## M25 junction 28 improvement scheme

TR010029

### 9.124 Applicant's comments on Grove Farm's Deadline 8 submissions

June 2021

**Fig 3.1 - HE Indicative alignment of amended Grove Farm egress (Change 8)**

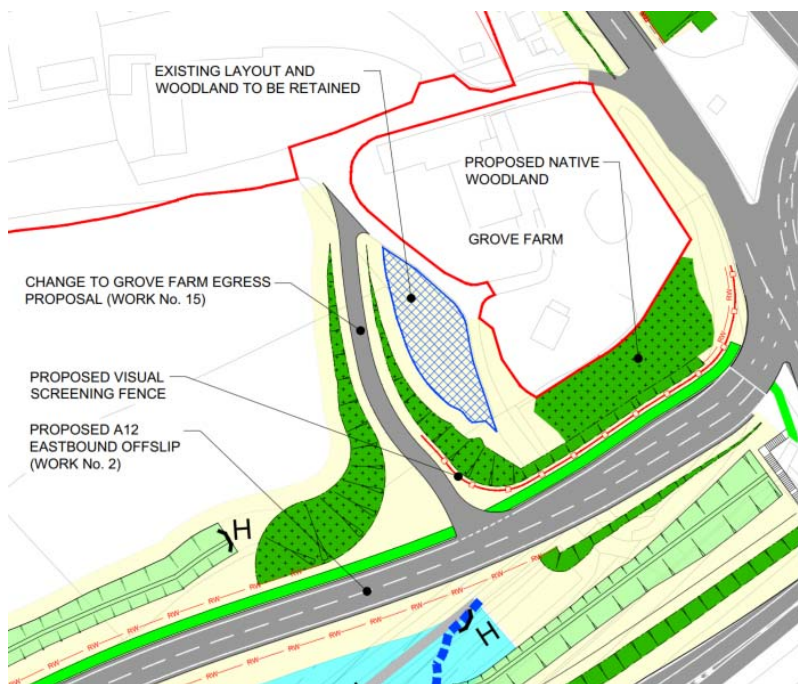
Response reference:	Question	Highways England Response
REP8-035-01	<p><b>1. Farm Entrance</b></p> <p>Highways England refer to 70mph speeds of vehicles passing our property and accelerating traffic as being the reasons why the access cannot be moved a short distance further north. Has there ever been a traffic speed survey at our entrance? As clearly vehicle speeds are not this high. Entrances off main roads where traffic is accelerating is very common around the country.</p> <p>The latest road layout will move our entrance closer to the roundabout. Our entrance will be affected, contrary to statements made by Highways England. We will on a daily basis then struggle daily with using the entrance when traffic continues to flow around the roundabout.</p> <p>Our experts consider moving the access north of the sub-station will make our entrance and the access for maintenance vehicles safer. After many decades living here, we agree. As mentioned in our</p>	<p>The reference made to 70 mph was concerned with the posted speed limit on the slip road and not vehicle speeds. As previously stated, vehicles leaving the roundabout are accelerating up to 70 mph on the slip road to merge with the M25 main carriageway. The existing entrance is sited close to the exit from the roundabout where vehicle speeds are low. A frequently used farm access sited further away from the exit of the roundabout (as suggested by the Grove Farm representatives) will be located where vehicles will be travelling at higher speeds as they accelerate away from the roundabout towards the M25. Highways England's road safety and operational safety engineers have expressed safety concerns about a frequently used entrance to the farm relocated further north on the slip road.</p> <p>Please see Highways England response to REP6-041-11 in (REP7-024) which sets out Highways England position. Highways England maintains its position with regard to the amended farm access proposal from the M25 on slip road as also set out in (REP5-047) and (REP6-012).</p> <p>A speed survey on the slip road adjacent to the existing Grove Farm entrance has not been undertaken by Highways England given that the proposed works by the Grove Farm access only comprises resurfacing. The existing farm entrance is situated close to the exit from the</p>

Response reference:	Question	Highways England Response
	<p>previous email, our children and grandchildren live here and we have to make sure that they are safe at all times.</p>	<p>roundabout where observed traffic speeds are low. The absence of any recorded accidents here reflects this.</p> <p>The proposed works on the roundabout carriageway and slip road exit to the M25 adjacent to Grove Farm involves resurfacing only. As such the position of the roundabout will not be changed and the existing entrance to Grove Farm will not be closer to the roundabout. Similarly, the existing layout on the slip road up to and including the entrance to Grove Farm will be unaltered.</p>
<p><b>REP8-035-02</b></p>	<p><b>2. Noise Barriers</b></p> <p>From the latest response it looks like you are going to allow a visual fence with further noise surveys later. At the last hearing, you were not satisfied that the noise survey was able to measure the highest noise levels caused by revving of engines screeching of brakes, use of car horns and sirens. The Highways England noise expert at the last hearing agreed that the loudest 10% of measured noise is not considered. These highest noises are the very noises that will cause us most concern but are being ignored.</p>	<p>Please see response to REP7-043-06 to Highways England's response to the Deadline 7 submission from Grove Farm (REP8-018).</p>

**Figure 3.2 – Grove Farm's suggested location for extra noise attenuation fencing**

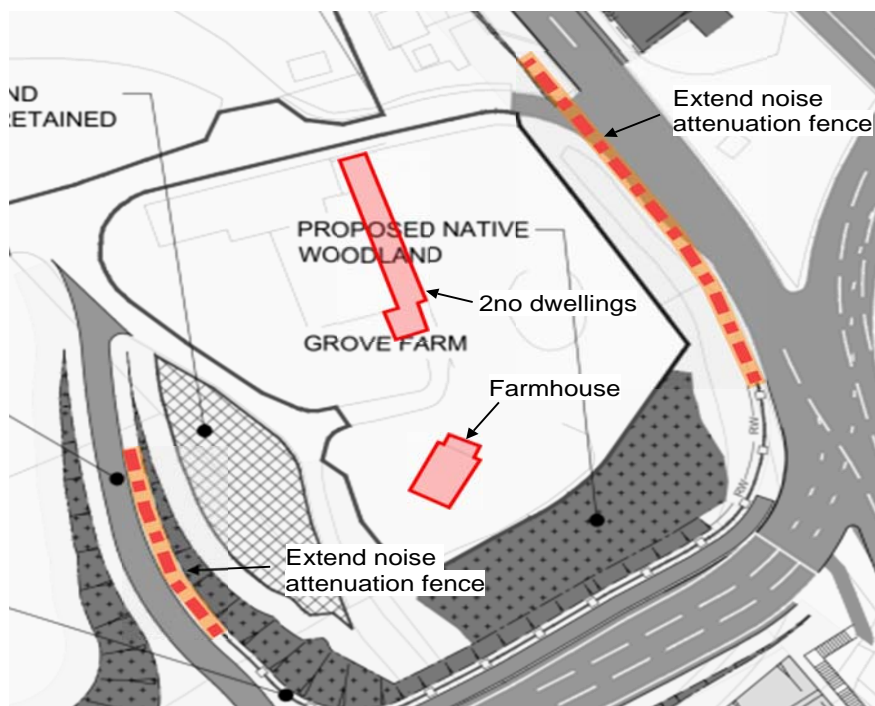
Response reference:	Question	Highways England Response
	<p>closer to our bedroom windows. This is why we need as a minimum the noise barrier around the front and sides of our properties. Our bedroom windows face directly on to the new and much closer proposed slip road. Tree planting will not provide any noise attenuation even when fully grown.</p>	
<p><b>REP8-035-04</b></p>	<p>We understand from statements made by Highways England that they are proposing to noise dampening tarmac on the road in front. Our experts have said that this tarmac would need to be replaced every 6-10 years at least to keep the noise dampening effect and will be covered in any event near to the traffic signals with a coloured skid surface. They need to undertake to replace this tarmac regularly?? Surely this tarmac with its little holes in it to take the noise will fill up with dust and dirt over time making it pointless.</p>	<p>Please see response to REP7-043-08 in Highways England's response to the Deadline 7 submission from Grove Farm (REP8-018).</p>

<p><b>REP8-034-05</b></p>	<p>We are grateful that the Examining Authority came out and stood at various points to understand the human element of this scheme but we ask that the noise barrier is not considered as an afterthought but now as part of the initial construction of the</p>	<p>Please see response to REP7-043-05 to Highways England's response to the Deadline 7 submission from Grove Farm (REP8-018) which states that an acoustic barrier would need to meet the necessary acoustic standard. The increased density and weight of the acoustic barrier panels to meet the acoustic standard would require more substantial foundations than a visual screening fence in order to</p>

Response reference:	Question	Highways England Response
	<p>barriers. If a barrier is already going up surely it is more cost effective to only put up one appropriate barrier up that will benefit us more long term.</p>	<p>support this type of barrier. Moreover, such a noise barrier would offer no acoustic benefit (there being no acoustic change) and its cost would not represent good value for money for the public purse.</p>
<p><b>REP8-034-06</b></p>	<p><b>Summary</b>            Highways England has not considered the full effect of their scheme on our family. Moving our entrance further north to a safer location and providing noise barriers instead of visual fencing is the minimum that would be acceptable to us to mitigate against all the detrimental effects of this project on our family. Our daily mental health due to the road being moved within 20m of our homes and the increase in traffic cannot be taken lightly. These requests are entirely reasonable, but it seems they are not decisions that Highways England are able to take. We would ask you to consider our situation outside their technical constraints and agree with us what we are asking for is the very least that can be provided.</p>	<p>Please see responses above and to REP7-043-06 in Highways England's response to the Deadline 7 submission from Grove Farm (REP8-018).</p>
